CITY OF ALBUQUERQUE

July 20, 2016

**Re: Midtown Storage Units
4335 Cutler NE
Traffic Circulation Layout
Engineer's/Architect's Stamp 7-15-16 (H17-D105)**

PARKING BARRIER
FOR LIGHT
DUTY VEHICLES
NTS

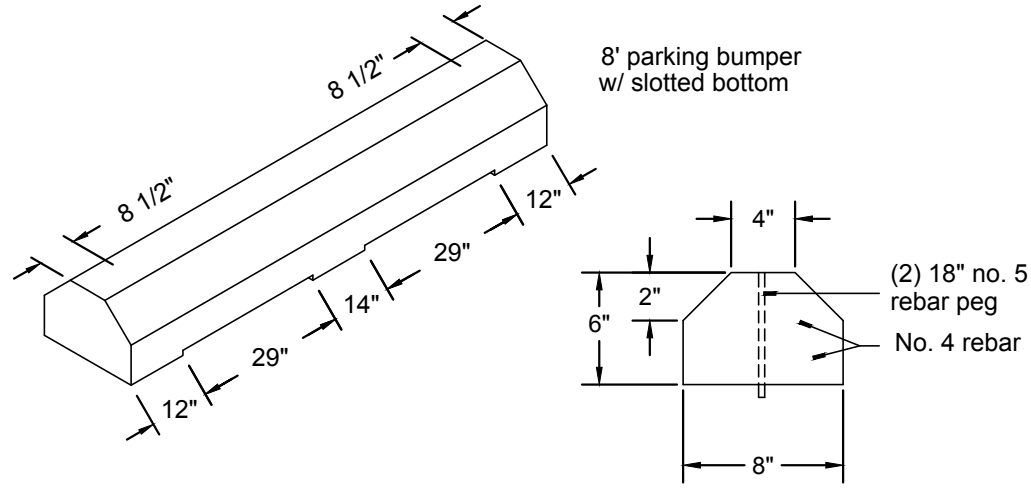
8. Required bicycle parking for residences, nonresidential, schools, and other facilities (Zoning Code, 14-16-3-1, B)
9. Provide a min 6" or max 8" high concrete barrier curb or other acceptable barrier between landscaping and parking areas and/or drive aisles. Please call out detail and location of barrier curb. Please call out this detail or detail the current barrier curb.

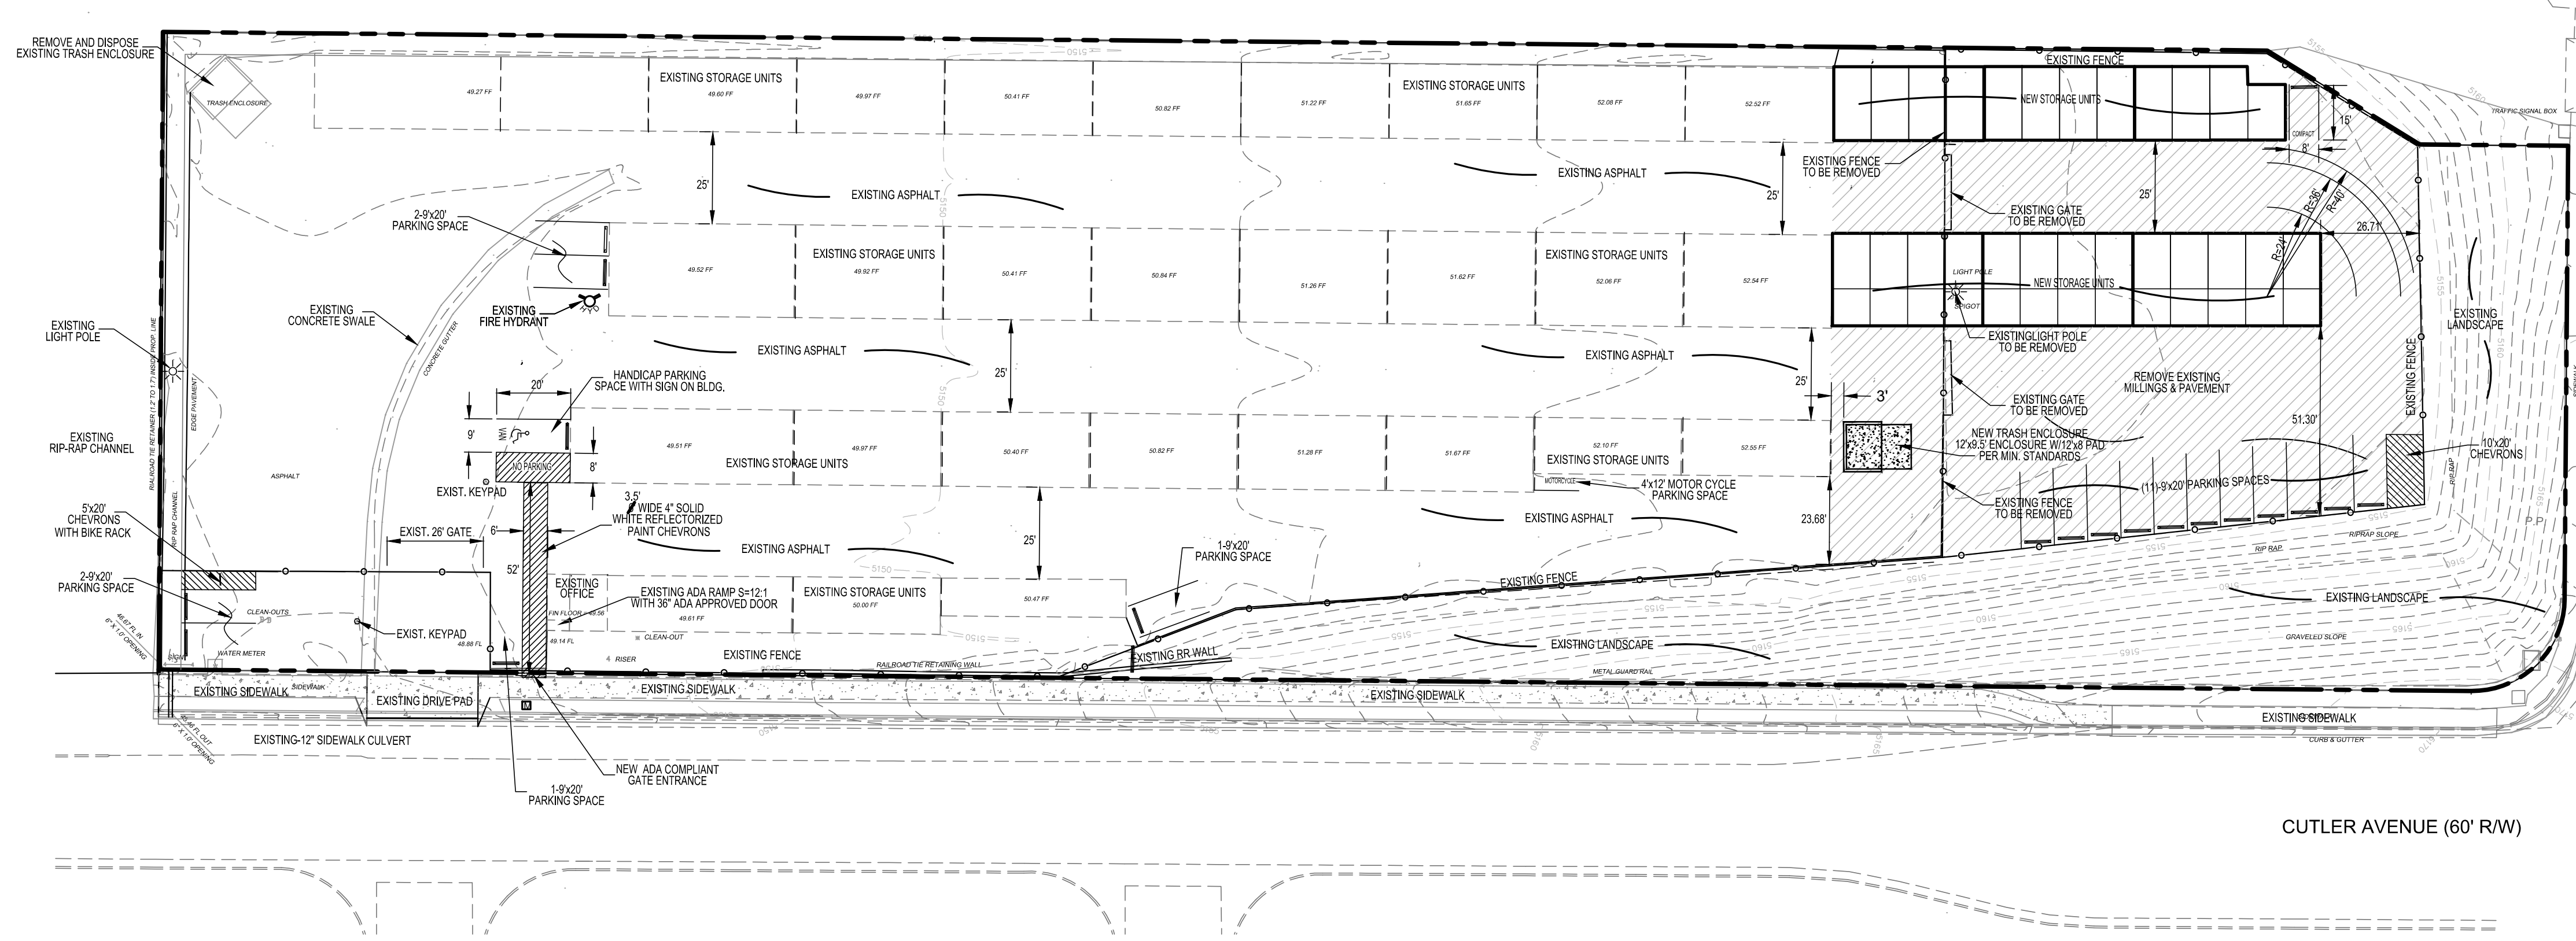
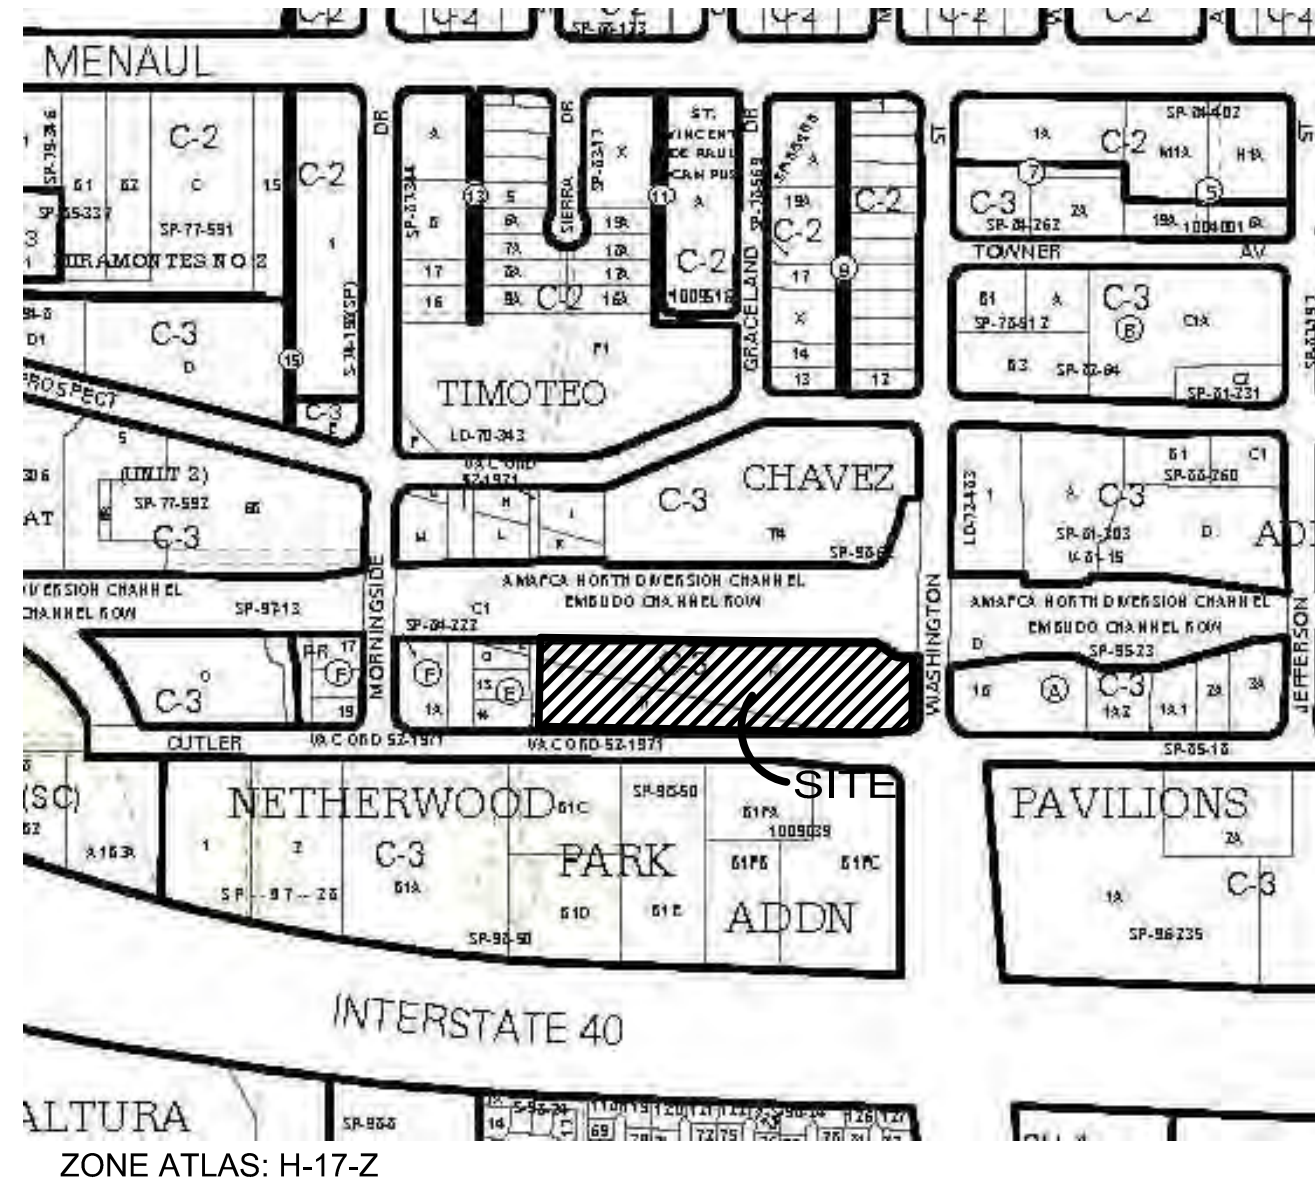
1. Please identify and dimension all existing doors, sidewalks, curbs, drive pads, wall and anything that influences the parking and circulation on the site.

2. Please identify and dimension all existing parking spaces.
3. Identify the right of way width, medians, curb cuts, and street widths on Cutler Ave.
4. Label the compact parking spaces by placing the words "**COMPACT**" on the pavement of each space.

5. Maximum aisle lengths of 400 ft. without internal circulation between aisles.
6. Per DPM, a 6 ft. wide ADA accessible pedestrian pathway is required from the public sidewalk to the building entrances. Please clearly show this pathway and provide details. Please provide and call out detail of striping of pedestrian pathway.

7. Per DPM, a 6 ft. wide ADA accessible pedestrian pathway is required from the HC parking stall access aisles to the building entrances. Please clearly show this pathway and provide details. ADA accessible pedestrian pathway cannot be located behind vehicular traffic.

10. Service vehicle and/or refuse vehicle maneuvering must be contained on-site; provide a copy of refuse approval.

13. Please add a note on the plan stating "All improvements located in the Right of Way must be included on the work order."
14. Unused curb cuts must be replaced with sidewalk and curb & gutter. A build note must be provided referring to the appropriate City Standard drawing.

15. All broken or cracked sidewalk must be replaced with sidewalk and curb & gutter. A build note must be provided referring to the appropriate City Standard drawing.

CLEAR SIGHT DISTANCE EXHIBIT
NTS

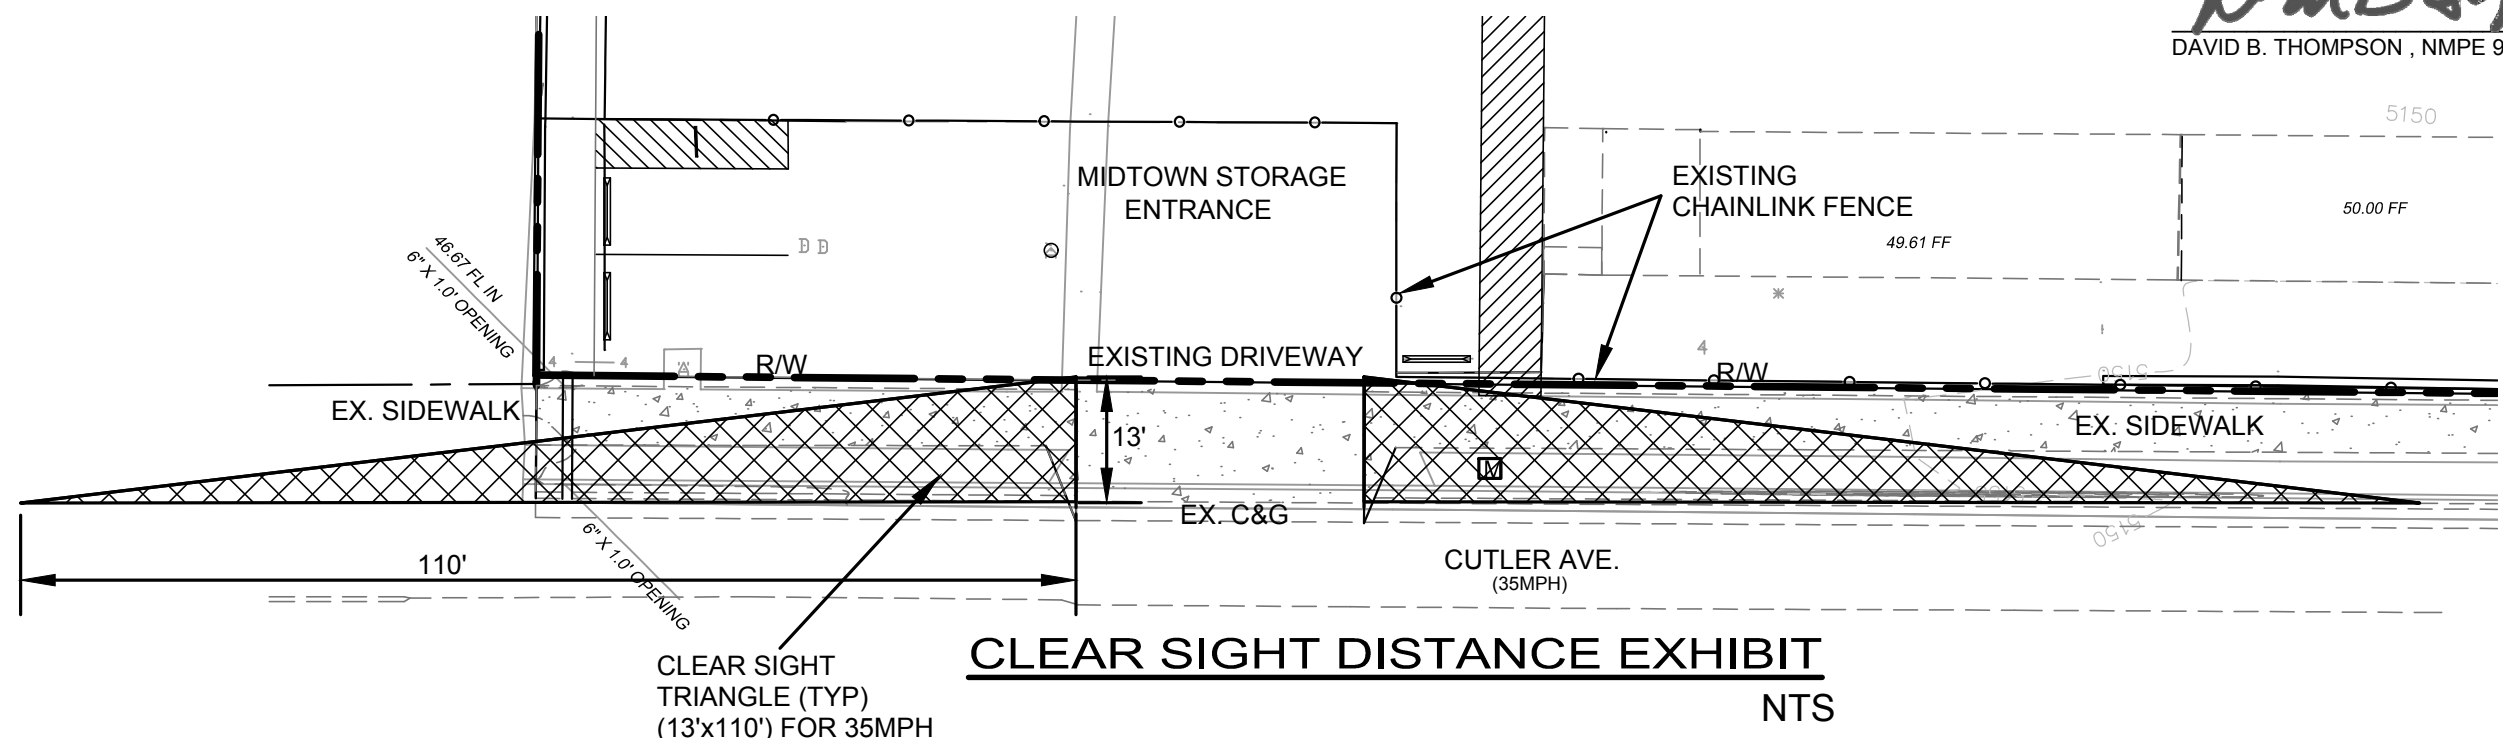
11. Please provide a sight distance exhibit (see the *Development Process Manual, Chapter 23, Section 3*). Please provide this detail for entrance/exit on Cutler Ave.

12. Please add the following note to the clear sight triangle: "Landscaping and signage will not interfere with clear sight requirements. Therefore, signs, walls, trees, and shrubbery between 3 and 8 feet tall (as measured from the gutter pan) will not be acceptable in this area."
